The Member-Secretary,
Madras Metropolitan
Development Authority,
No.8, Gandhi-Irwin Road,
Madras-600 008.

Letter No. A3/19258/90.

Dated: 29.10.1990.

Sub: MMDA - Planning Permission - Construction of building for Residential purpose in Plot No. 3 & 4, S.No.225/10 of Pushuthivakkam Village - Approval of - Regarding.

site plan SCALE : 1 INCH = 16' 0" (1:200)

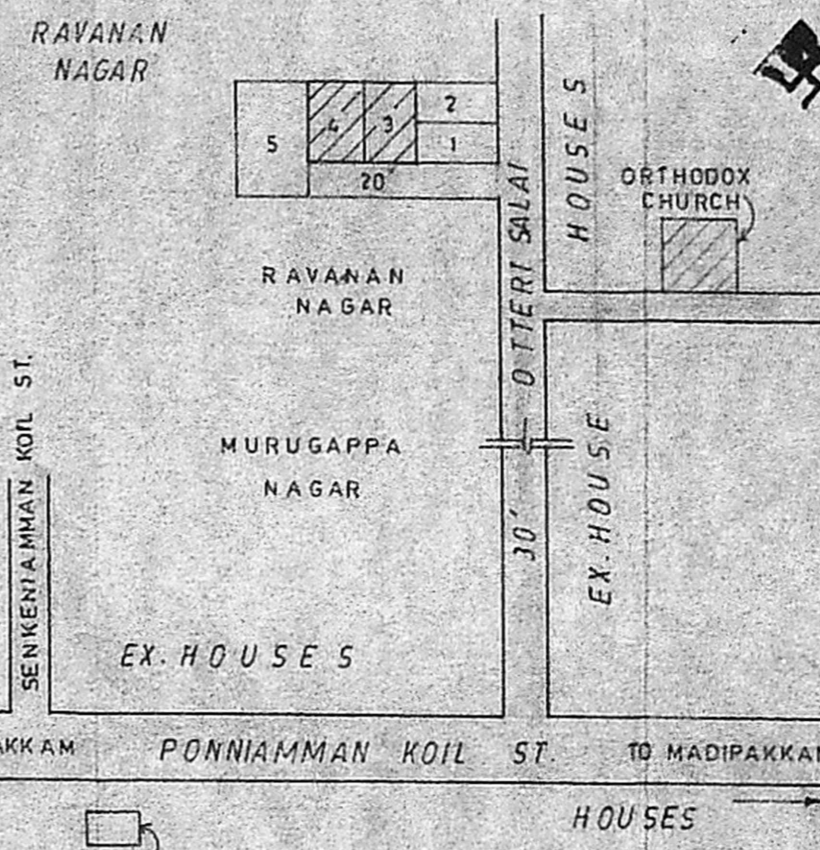
The proposal received in the reference cited for the construction of building for residential (Ground Floor) purpose at Plot No. 3 & 4 and S.No.225/10 of Pushuthivakkam Village was examined and found to be approvable subject to the condition that you are requested to furnish Revised Plan incorporating Water closet and Stair case landing in the site plan and with clear set back measurements all around.
